From: Contact Centre (CRM) <contact@ribblevalley.gov.uk>
Sent: 05 May 2026 18:02
To: Planning
Subject: Planning Application Comments - 3/2026/0250 FS-Case-834971298

Planning Application Reference No.: 3/2026/0250

Address of Development: 24 chapburn road clitheroe

REAR ELEVATION

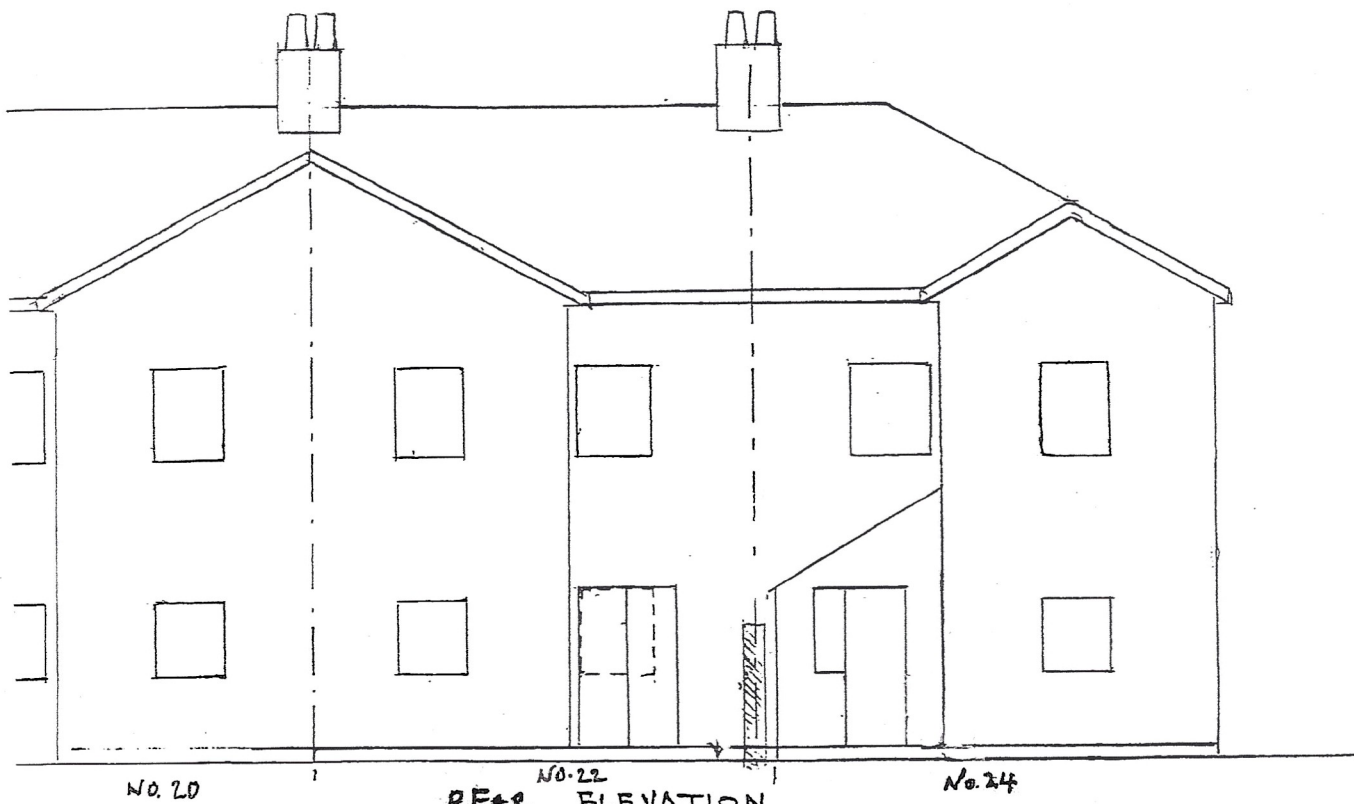
Comments: The small lean to to the rear elevations has not been constructed in line with current planning and building regulations, the building is causing extensive damage to [REDACTED], building control have been involved with the issues as have environmental health, plans and building regulation certificates were requested but could not be located or provided to confirm the extension was built correctly
